PLANNING BOARD REPORT #: 05-08

**THE ESTATES AT LONGFELLOW INN
130 EASTERN PROMENADE**

SITE PLAN AND SUBDIVISION REVIEW

Prepared on: January 18, 2008
Meeting Date: January 22, 2008

PROPOSED CONDITIONS DRAINAGE MAP
THE ESTATES OF LONGFELLOW INN
 130 EASTERN PROMENADE
 PORTLAND
 MAINE

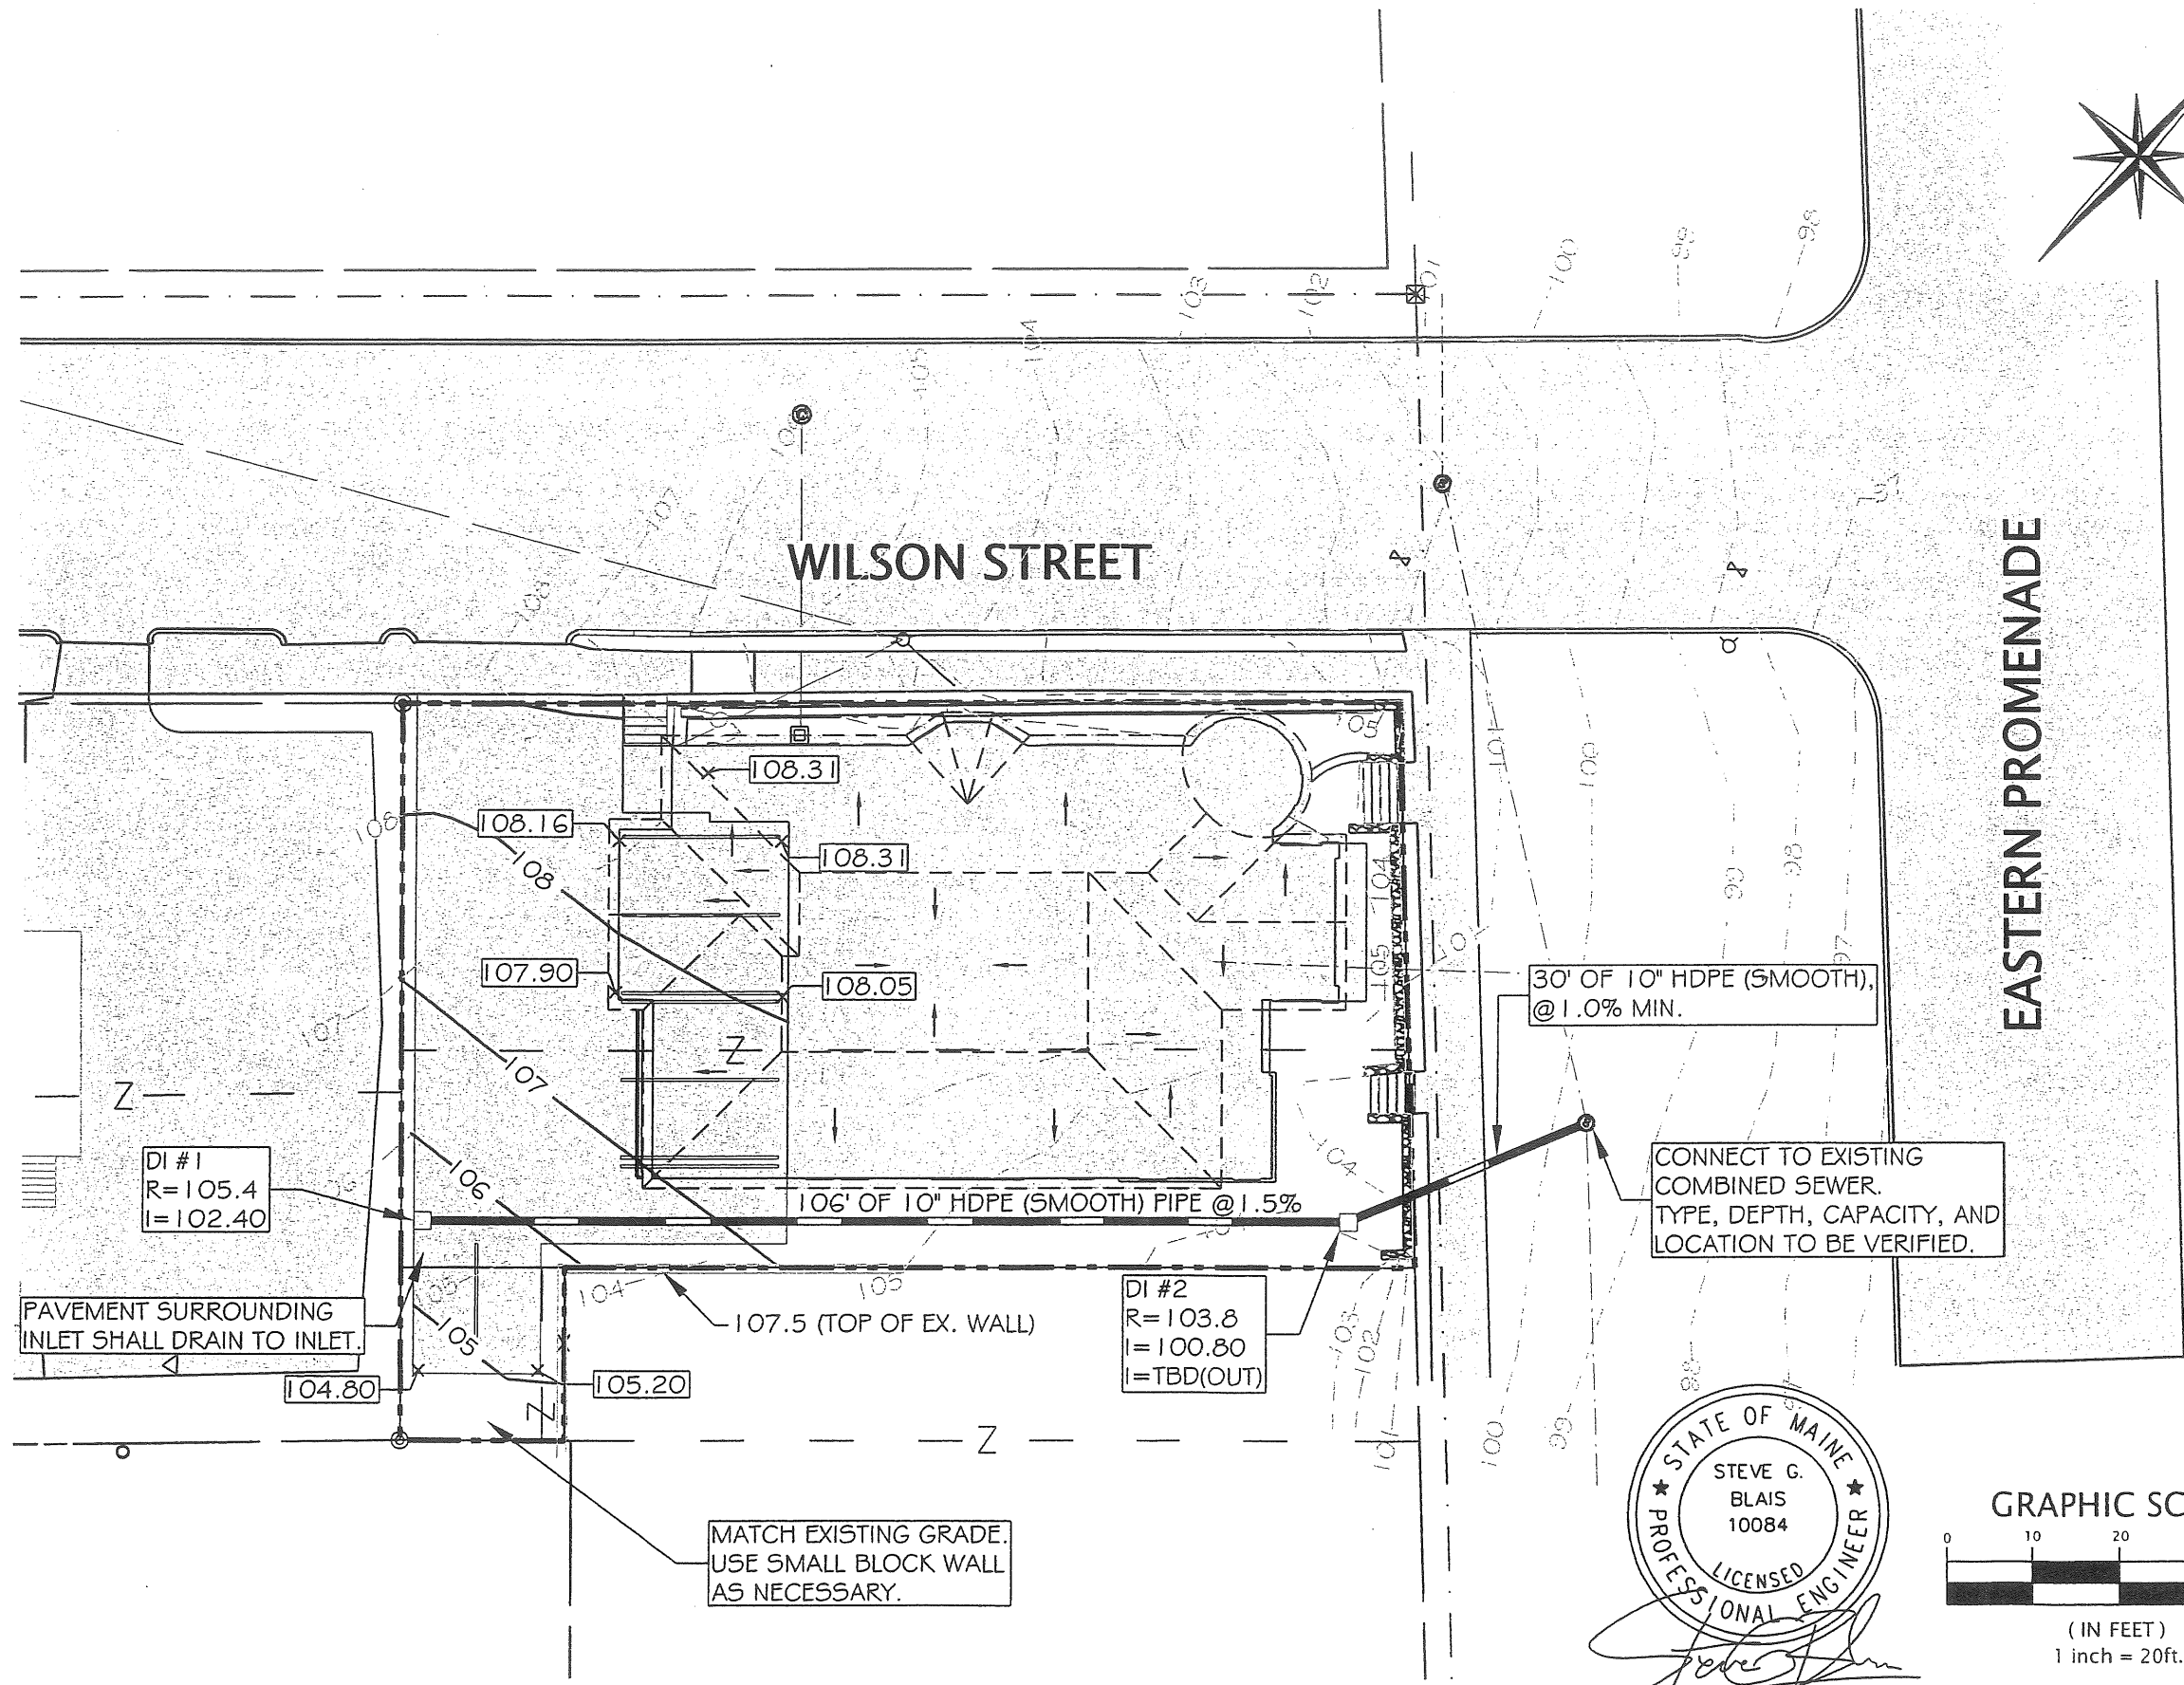
The submitted stormwater plan is included as Attachment 5. Engineering review comments from Dan Goyette, Consulting Development Review Engineer, are included as Attachment 7. Dan recommends minor revisions to the site plans pertaining to stormwater management. City Technical Standards stipulate that the rate of runoff of stormwater leaving the site after development shall not exceed the pre development rate. The City recognizes the difficulties that on-site detention poses to urban development. As the amount of impervious coverage increases, the quantity of water leaving the site will inevitably increase with it. The rate and quality of runoff, however, must be regulated. The submitted stormwater report shows that there will be a slight increase in flow for the post development site conditions. The capacity of the existing combined sewer system and the effect of the proposal's stormwater and sanitary sewer flows on the system must be verified and taken into account in the design prior to approval. The applicant submitted revisions addressing Dan's comments on January 2, 2008 (see Attachments 16 and 17). These revisions have been submitted to but have not yet been approved by Public Works.

Planning staff recommends including a condition of approval that revisions to the stormwater management plan must be reviewed and approved by Public Works prior to the issuance of a building permit.

11(9)

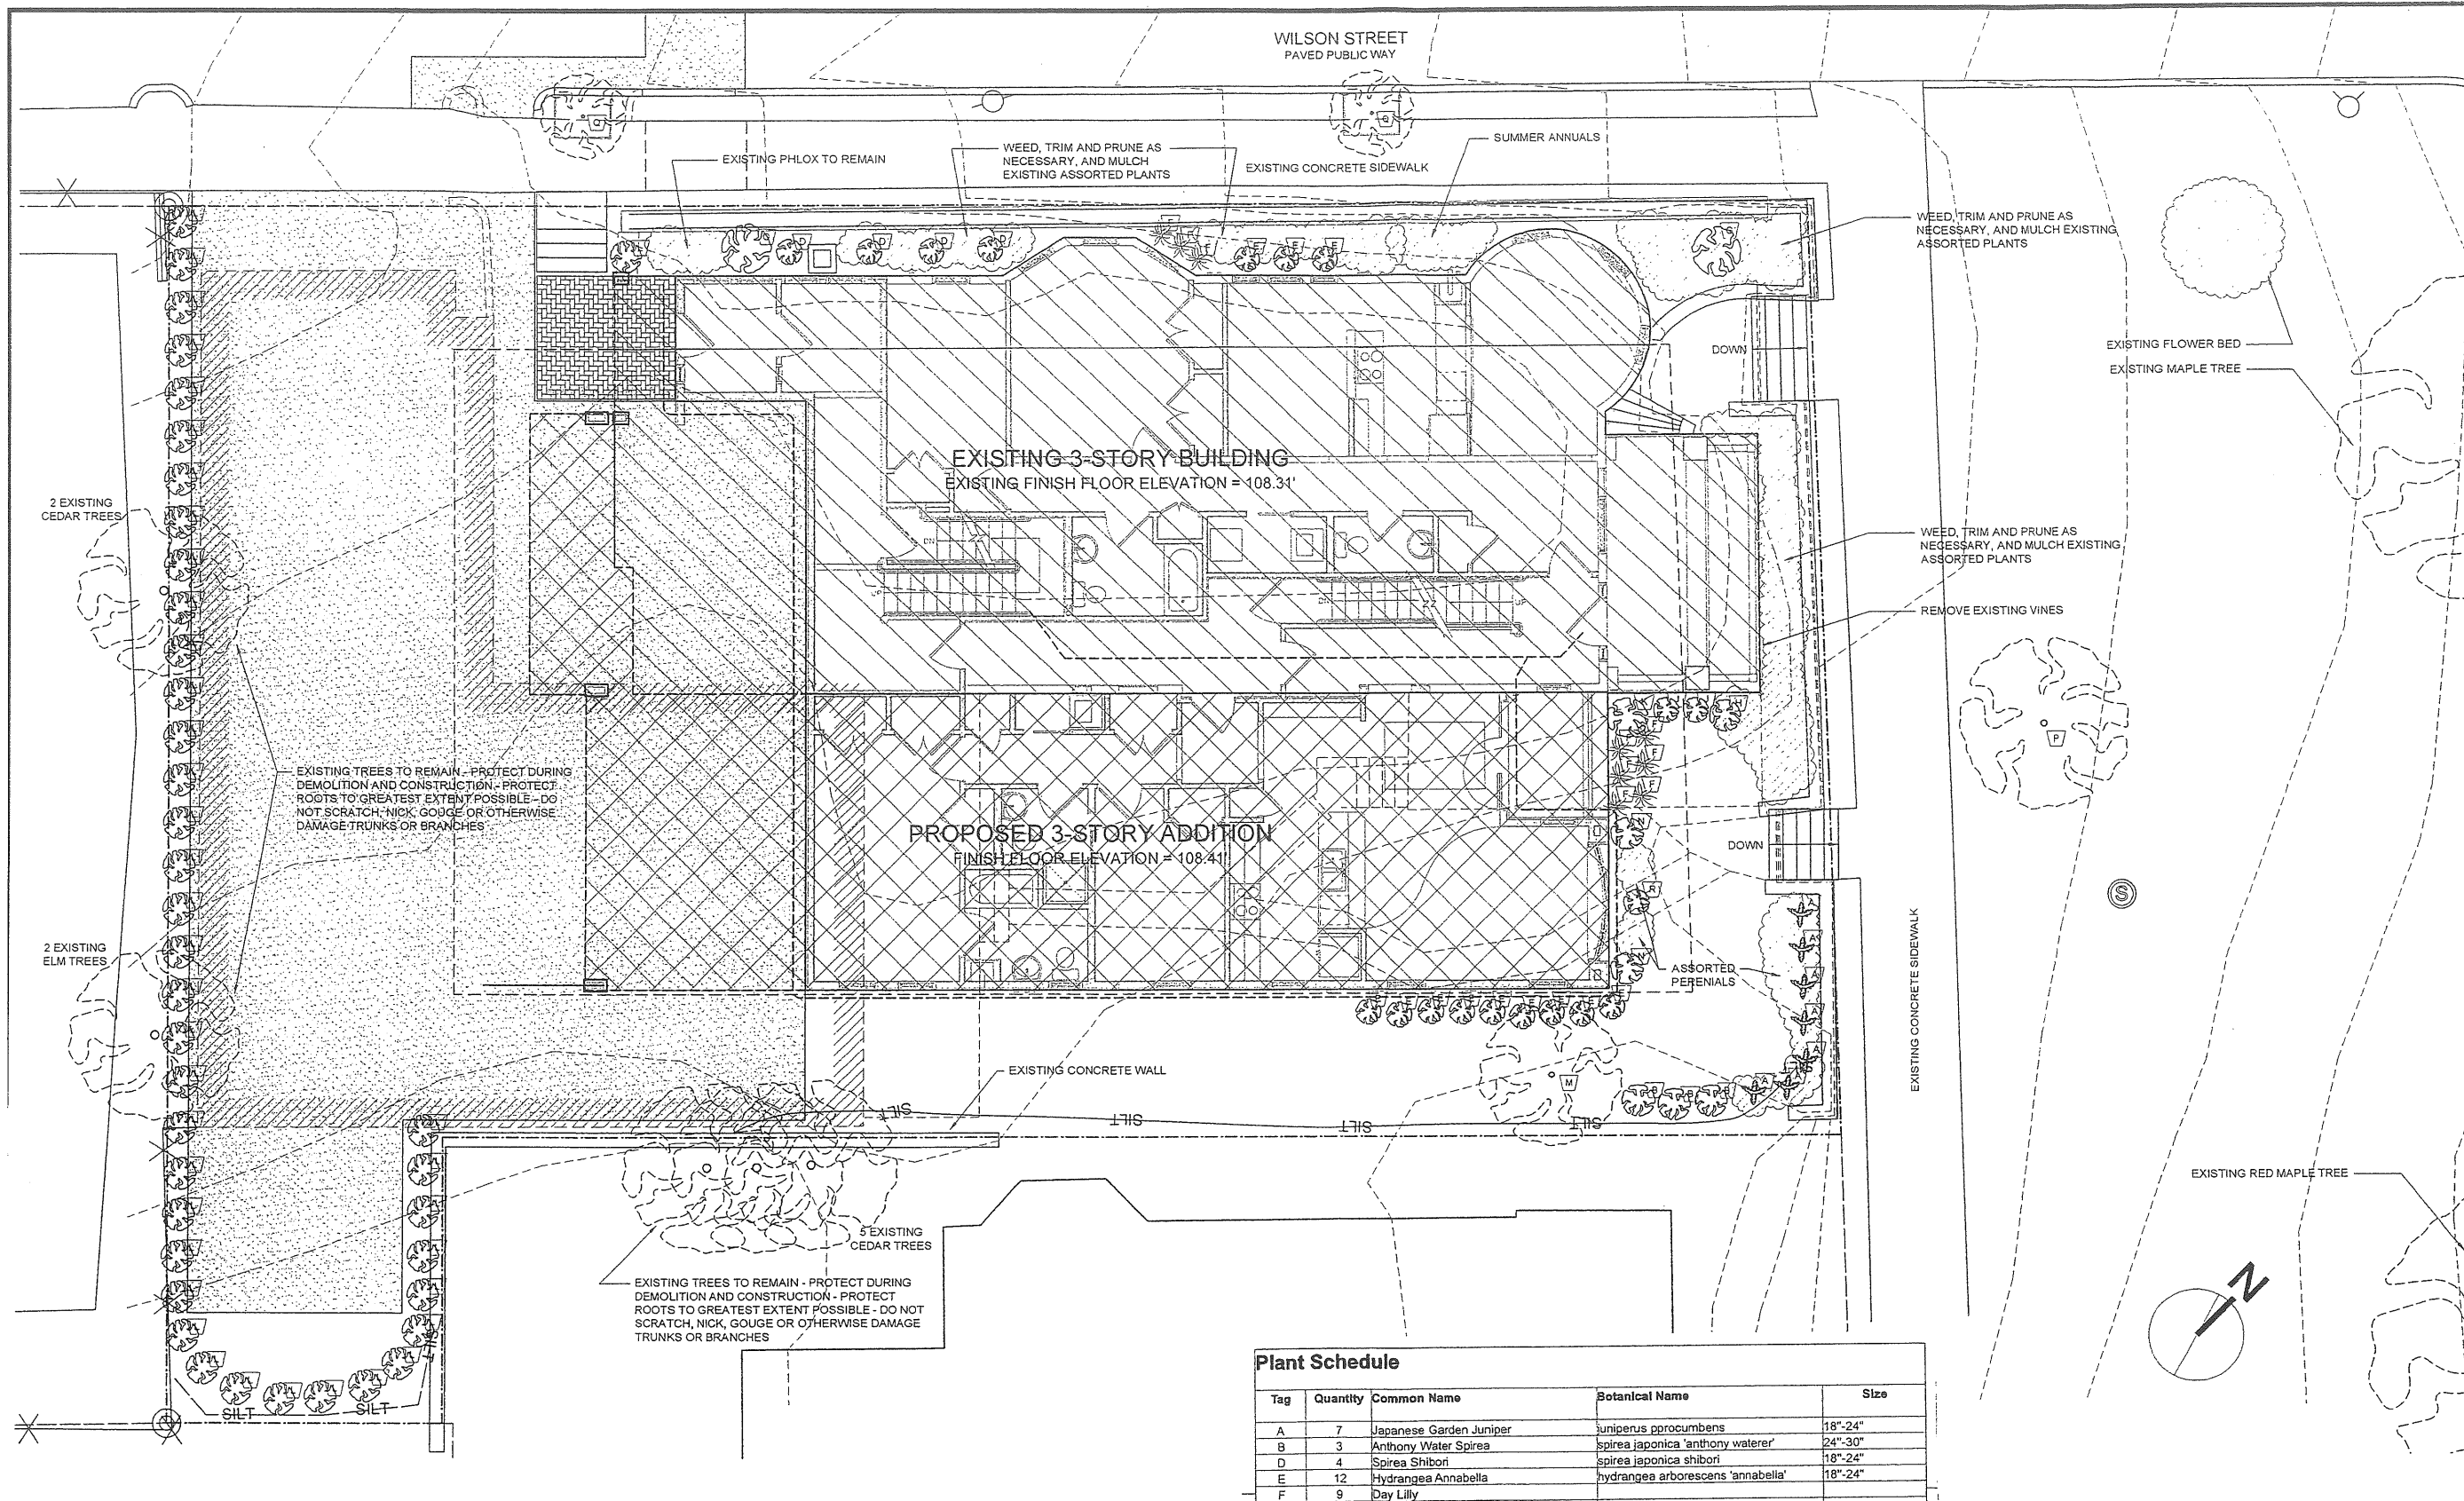
The applicant has submitted a revised landscaping plan for review (Sheet C1.4- Attachment 14(g)). The applicant proposes to add assorted perennials and a weeping cherry (*prunus snowfozam*) above the retaining wall along Eastern Promenade. The plans include measures to both enhance and preserve the existing planting beds along the Eastern Prom and Wilson Street frontages with summer annuals and perennial species. As previously stated, the applicant proposes to plant forty five (45) arborvitaes around the parking area as screening. In addition there are two mature cedar and two mature elm trees along the southwest property boundary, between the proposed parking area and an abutter's existing parking lot. The submitted landscaping plan identifies measures to preserve these trees during construction.

Jeff submitted review comments for the most recent plans (see Attachment 10). In summary, Jeff notes that the landscape treatment of ornamental shrubs and landscape beds fits into the character of the nearby residential landscape. Jeff noted that the proposed Elm tree along the Eastern Promenade should be revised to an Autumn Blaze Maple in order to reflect revisions to the Eastern Promenade Street Tree Plan, Atlantic Street to Wilson Street segment, as designed by Regina S. Leonard, Landscape Architect and submitted by Woodard and Curran for the Eastern Promenade Master Plan Improvements. Jeff also suggests the following conditions of approval:

5. The proposed street tree along the Eastern Promenade should be revised to show an Autumn Blaze Maple (*Acer freemanii*). This change to the plans must be reviewed and approved by Jeff Tarling, City Arborist prior to the issuance of a building permit.
